From: Andrew Wood
Sent: 10 July 2017 16:29
To: Planning.Responses
Subject: FW: FG/198/16 - Plans

From: Ed Miller [REDACTED]
Sent: 03 July 2017 16:04
To: Andrew Wood
Cc: sally henderson; Craig Savage; Roger Elkins; Carole Robertson
Subject: FG/198/16 - Plans

FIRST FLOOR PLAN

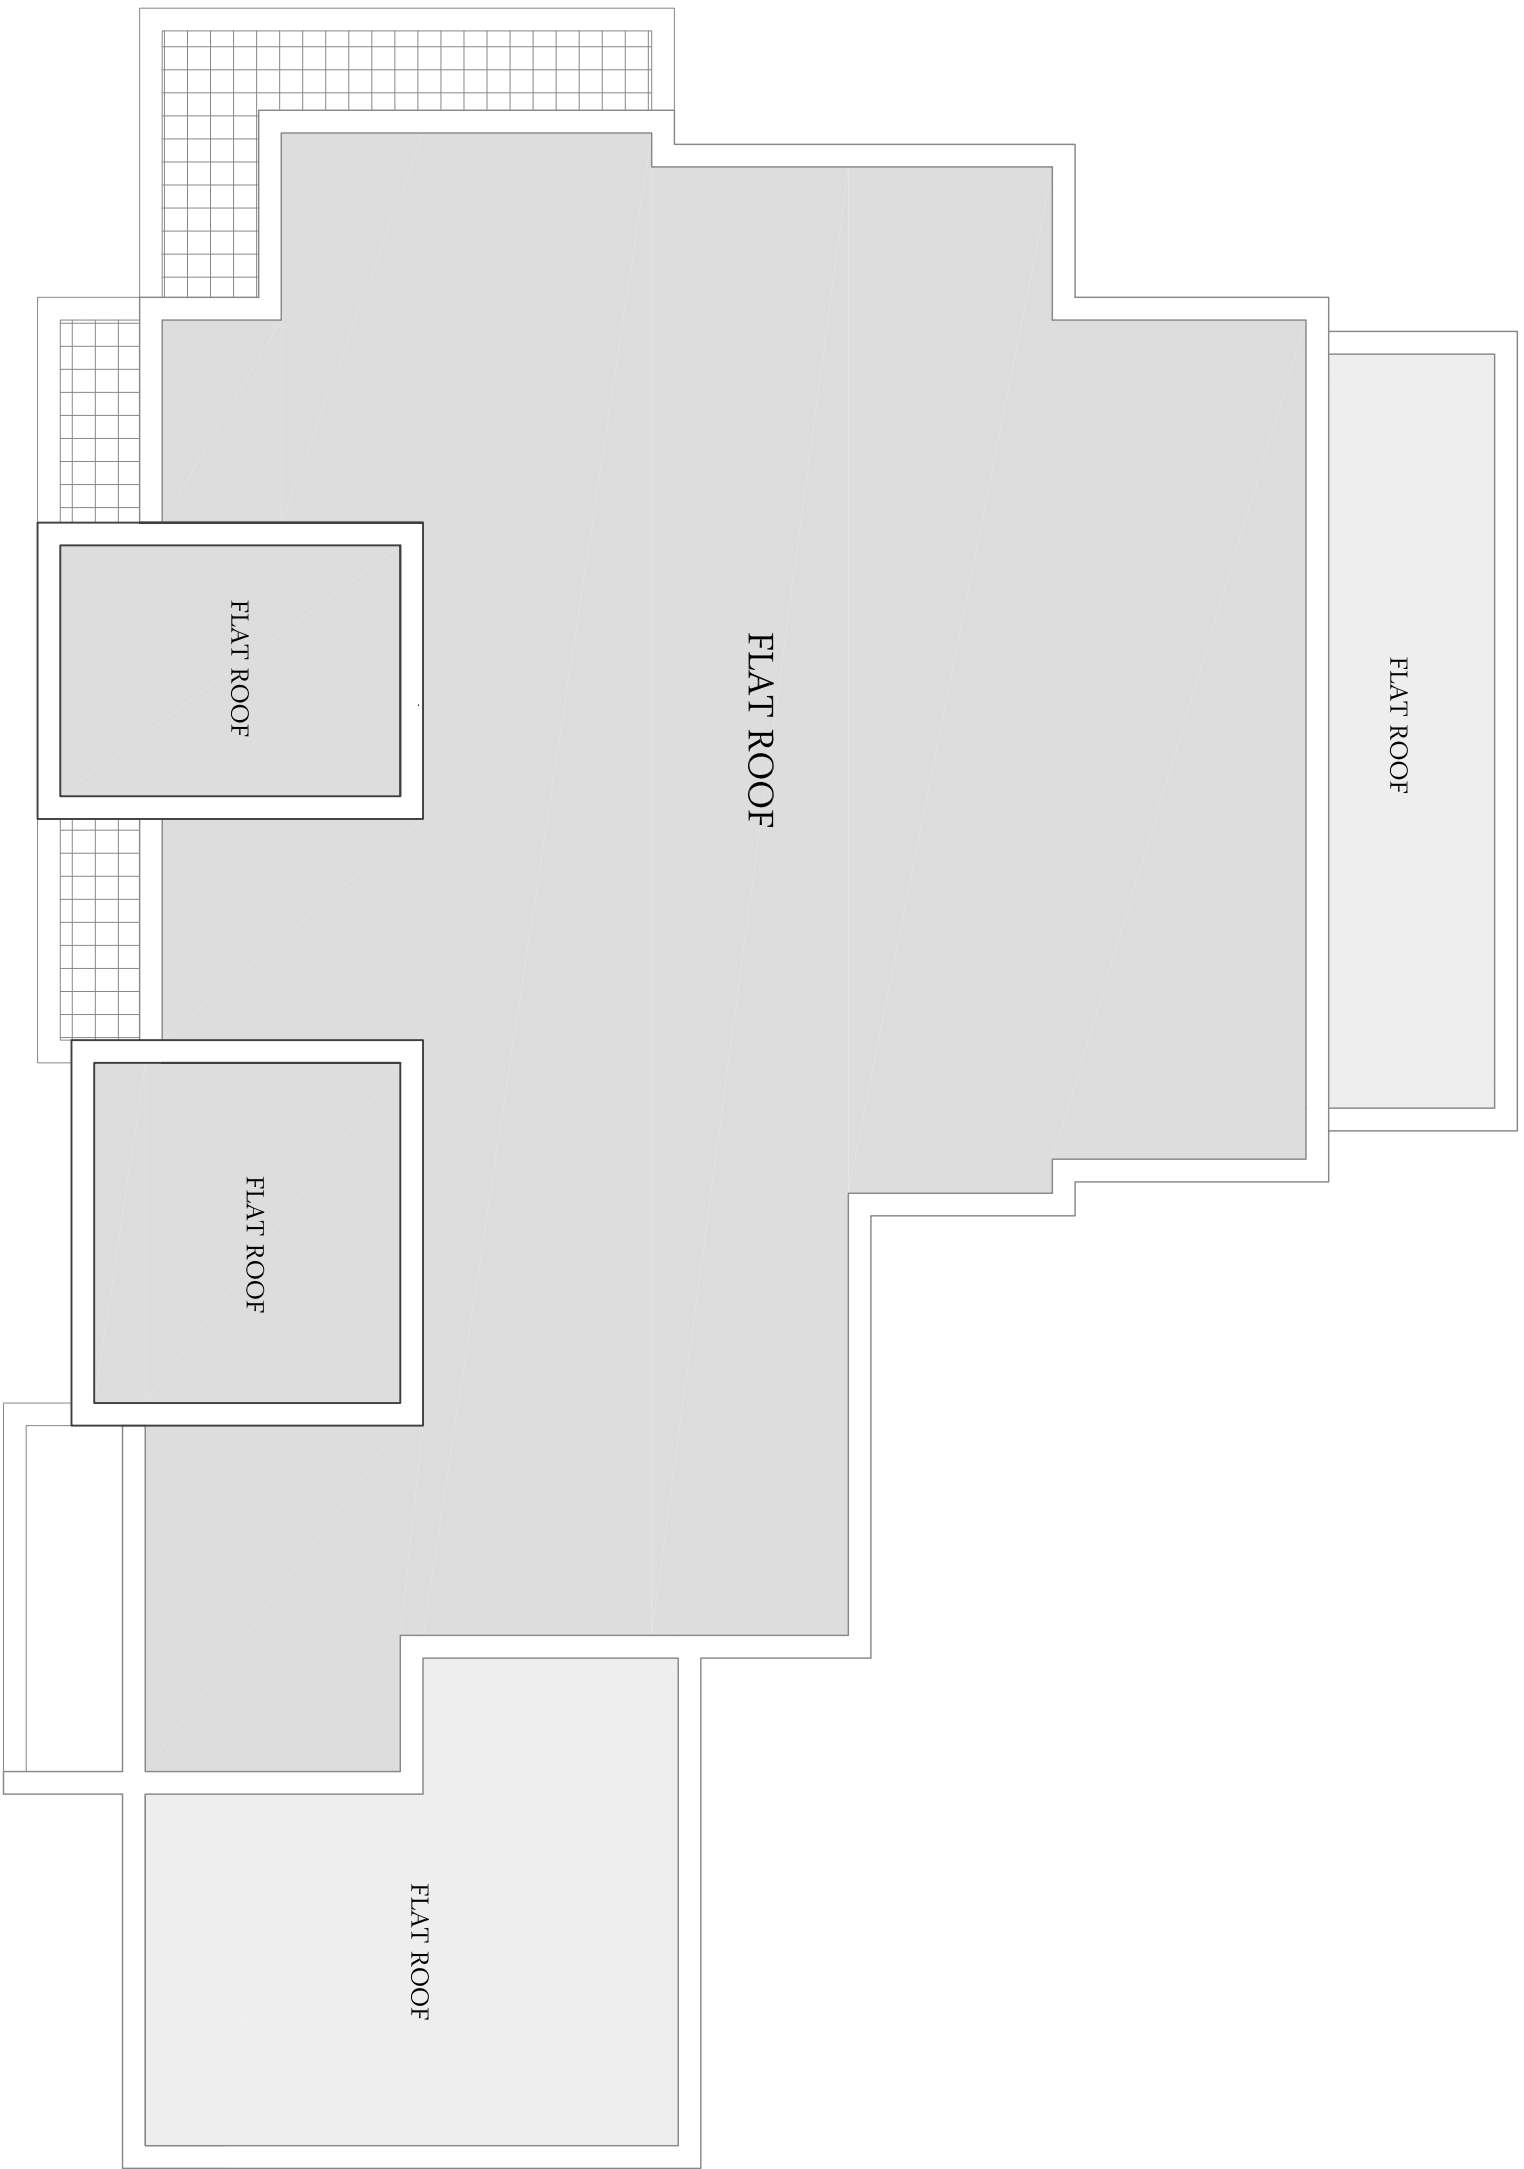
Mr Wood: Neither the latest Ground floor Plans nor the Street Scene, Sea Drive, both recently submitted, show any parking places fronting onto Sea Drive. But the covering minute from the architects, covering the revised plans (posted 29 June) refers to 12 parking places in all. The plan for the underground car park shows spaces numbered 3 to 12: are spaces 1 and 2 still intended to be on the ground floor, fronting Sea Drive? If so, why are they not shown on the latest plan and street scene? Isn't the absence of these prominent features very misleading for Members of the Development Control Committee when they come to consider the application. Or is there something I have misunderstood?- Ed Miller (Secretary, Ferring Conservation group)
